Recommendation Report for Planning Permission for Works or Extension to a Dwelling

REF NO: BR/64/21/HH

LOCATION: 16 Glenway
Bognor Regis
PO22 8BU

PROPOSAL: Single storey side extension to replace existing single storey garage, and bay window to front elevation.

PROJECT TITLE: 16 GLENWAY BOGNOR REGIS	DRAWING TITLE: PLANS AS PROPOSED
--	-------------------------------------

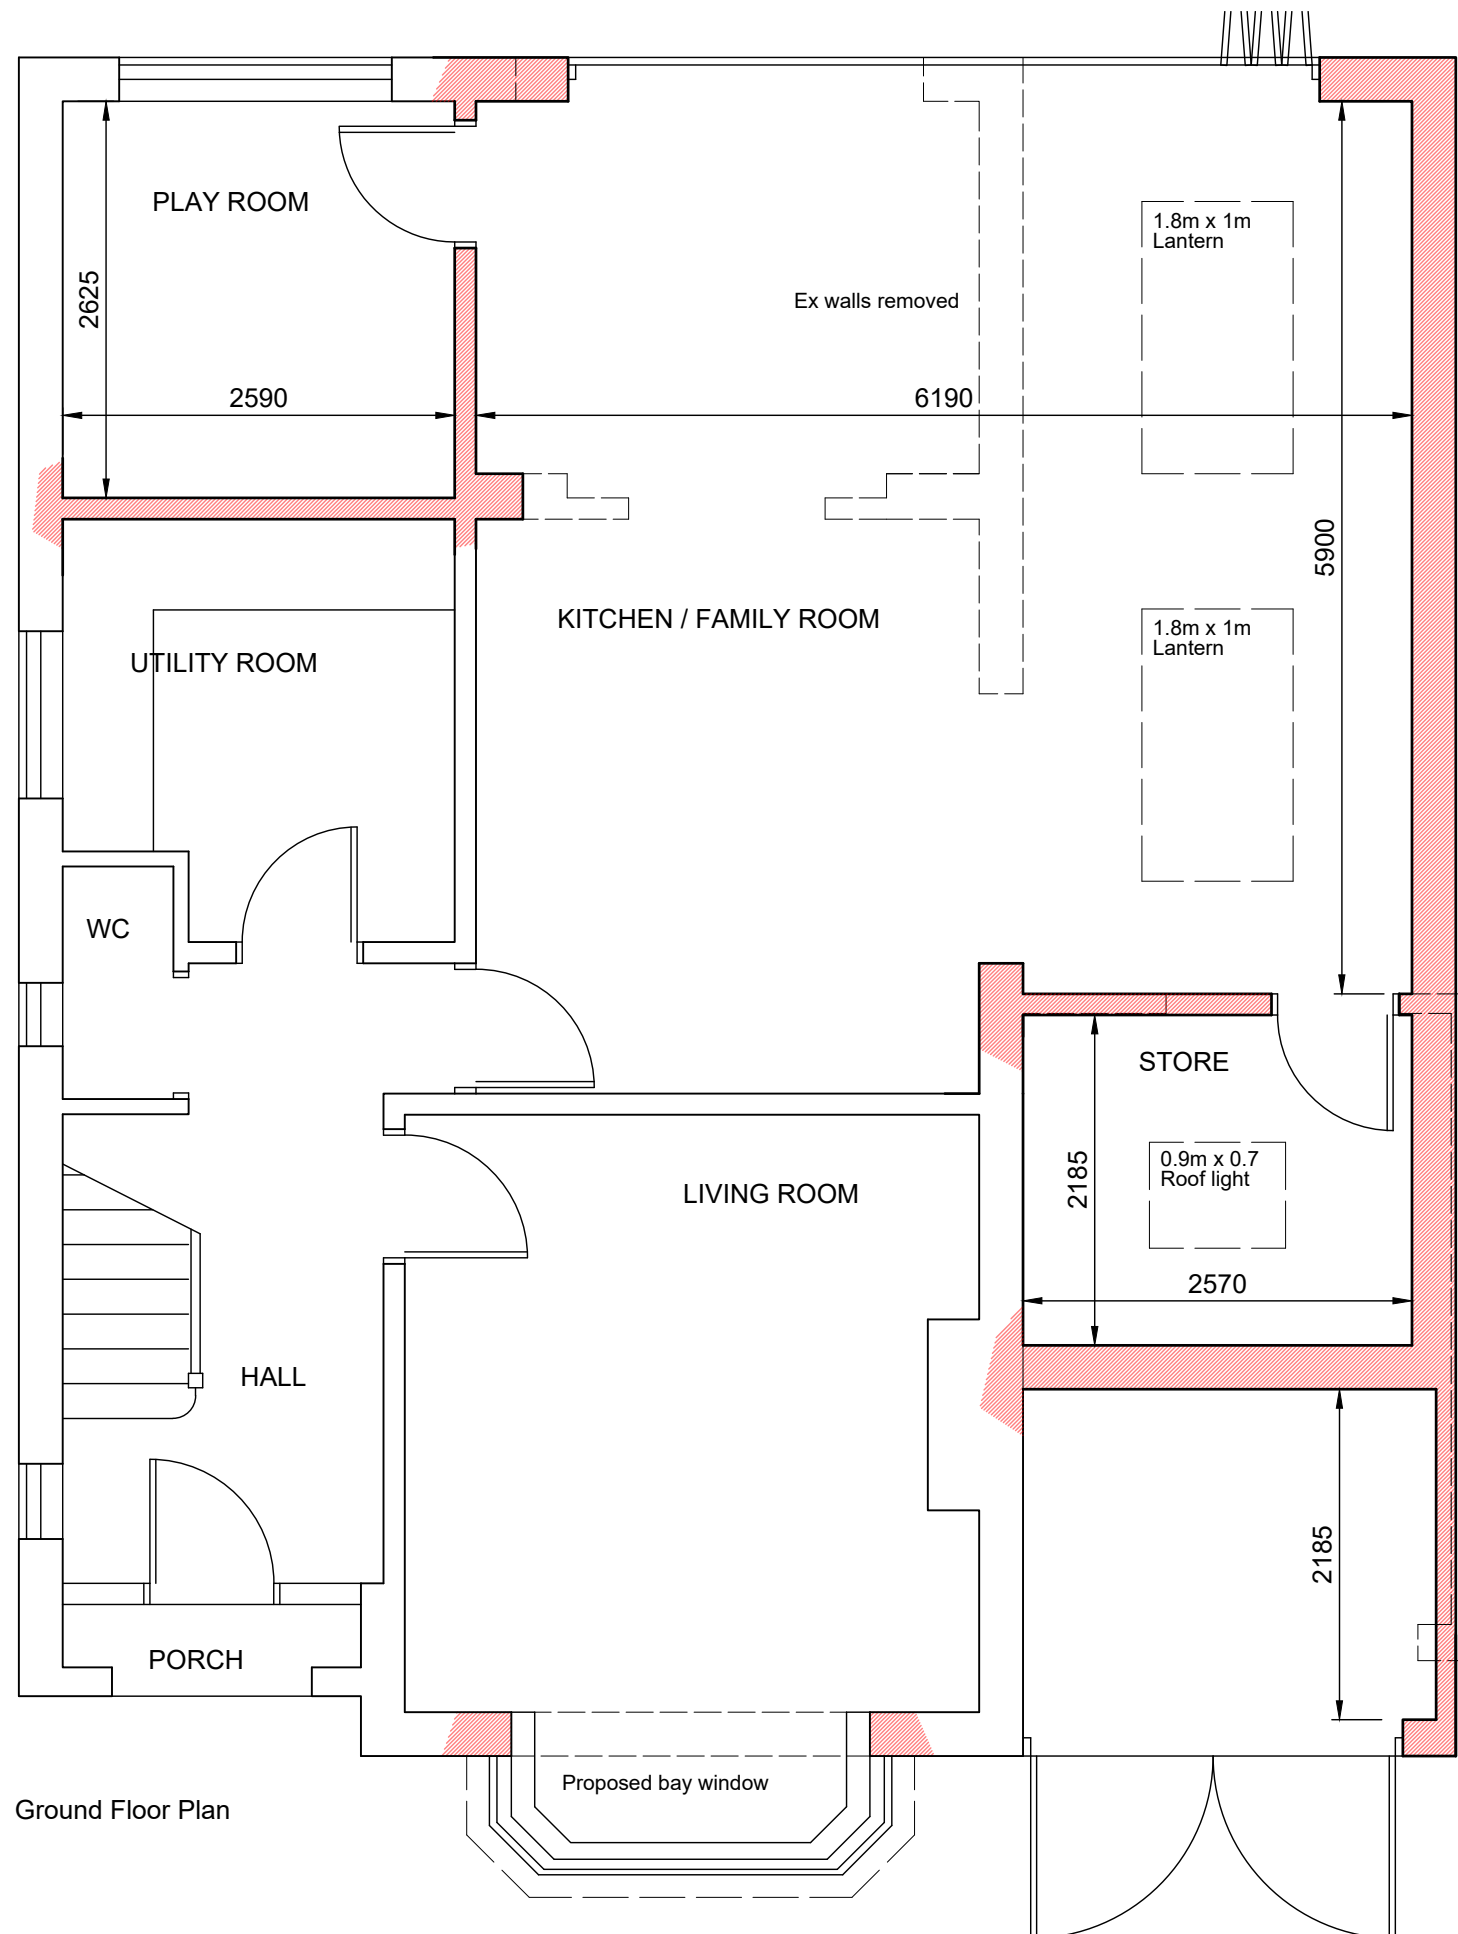
The site is occupied by a detached two storey dwelling with attached garage. The single storey side extension will replace the single storey garage on the west side of the property. The bay window will be constructed on the front north side elevation. The proposal includes blocking up the window at first floor on west side elevation of host dwelling.

The single storey side extension will have a width of 11.09m and a depth of 2.66m. Due to the siting of the side extension it will be highly visible from the street scene, however it will be subservient to the main dwelling and the flat roof design will integrate it into the overall design of dwelling and character of the area. The siting of the side extension will be moved forward by around 0.68m however it will be positioned in line with the existing principal front northern elevation so is considered acceptable. To the rear of the property, the side extension will line up with the existing southern rear principal elevation of the property.

The side extension runs along the west side elevation of property and infill to the rear elevation of the property. The extension will have a width of 11.09m, depth of 2.66m and height of approximately 3.10m. Due to the siting of the side extension it will cause some overshadowing to the front facing northern window of neighbouring property to the west at number 14. However it is not deemed to have adverse overshadowing or overbearing effect due to the existing boundary fence and due to it being at single storey.

Due to the siting of the of the extension it will be sited less than 1m to the western side boundary. However the extension does not contain windows on west side of extension elevation so it does not increase overlooking to neighbouring properties to the west. The extension does contain new bi-fold doors facing the garden to rear however there is 10.35m remaining to the rear boundary so this large gap reduces impact of overlooking to neighbouring properties to rear and complies with Policy D DM4 of Arun Local Plan.

Front Elevation - North

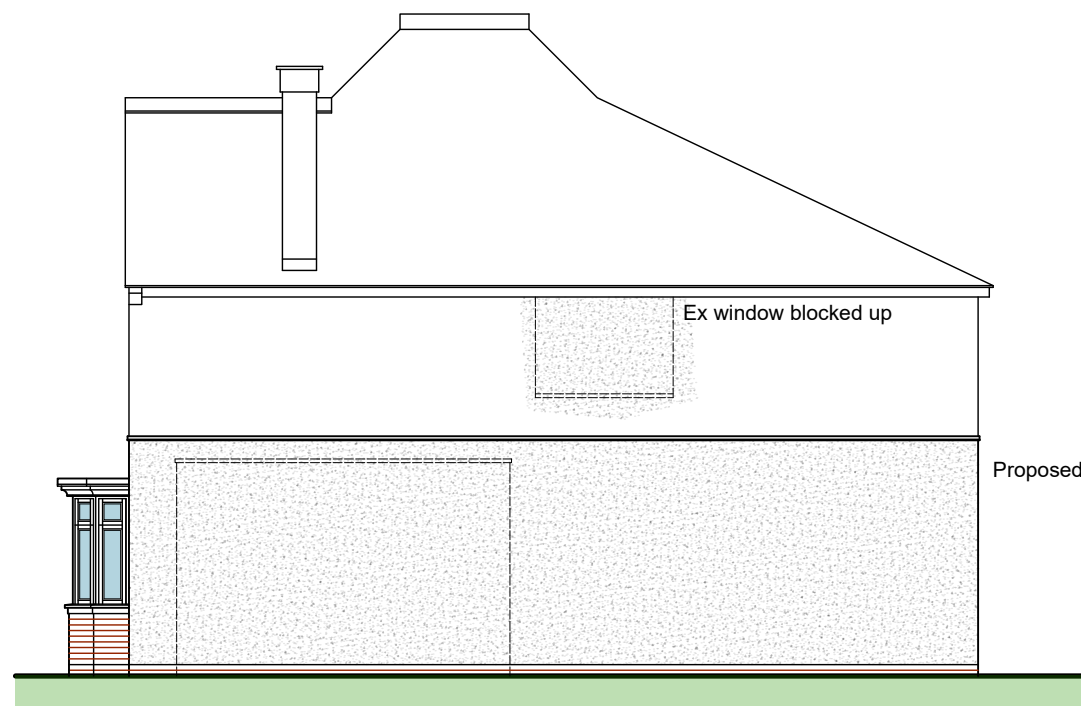
The new bay windows will be located at the front north side elevation of property. They will have a width of 2.67m and depth of 0.74m. Due to the siting and design of the bay windows, they seem well integrated with the existing host dwelling and the siting lines up with the existing building line of neighbouring property at number 14 which also has similar design of bay windows at front.

The bay windows located at the front north facing elevation of property are on the principal elevation. Due to the siting of the bay windows there is around 4.96m remaining to the front boundary of property. They will have a width of 2.67m, depth of 0.74m and a height of around 2.56m. There will be slight risk of overlooking into the neighbouring bay windows of property to the west at number 14 however it is not deemed to be significantly adverse. The bay windows will be positioned beyond the building line of the neighbouring property to the east at number 18 so will not cause overlooking effects to the east side boundary of dwelling.

Rear Elevation - South

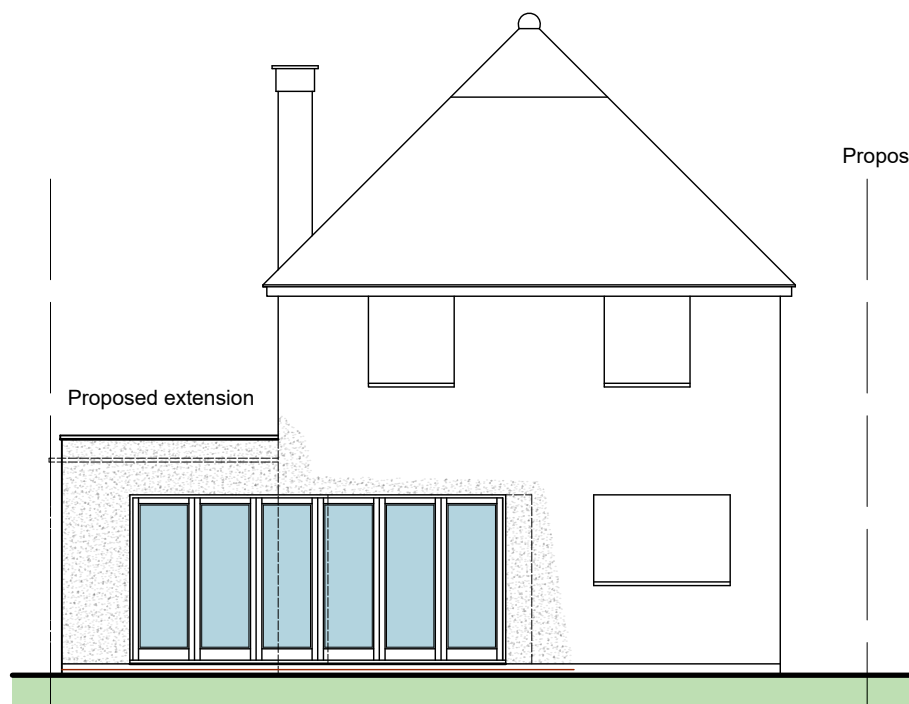
The extension will have double doors on the north side of the proposed extension facing the driveway and bi-fold doors on the south side rear elevation facing the garden. There will be one roof light and two roof lanterns on the extension flat roof.

Proposed Roof Plan

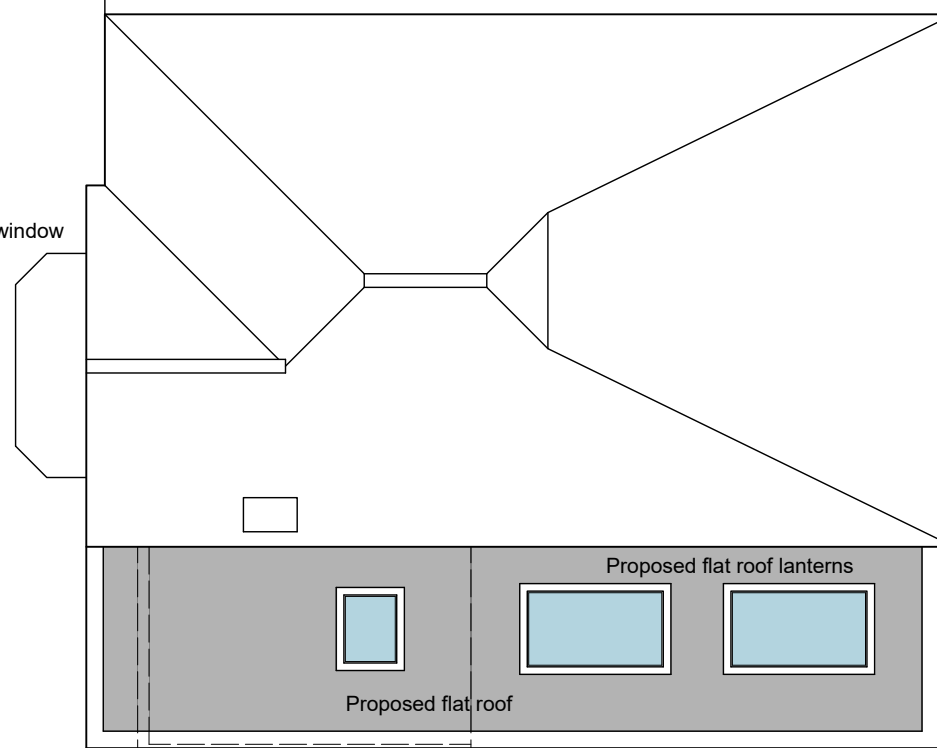
The materials used on the extension will match existing and consist of dash coat render brick walls, a GRP flat roof, PVC double glazed doors and FLB timber store doors. The proposed materials visually integrate with the existing dwelling so comply with D DM4 of the Arun Local Plan.
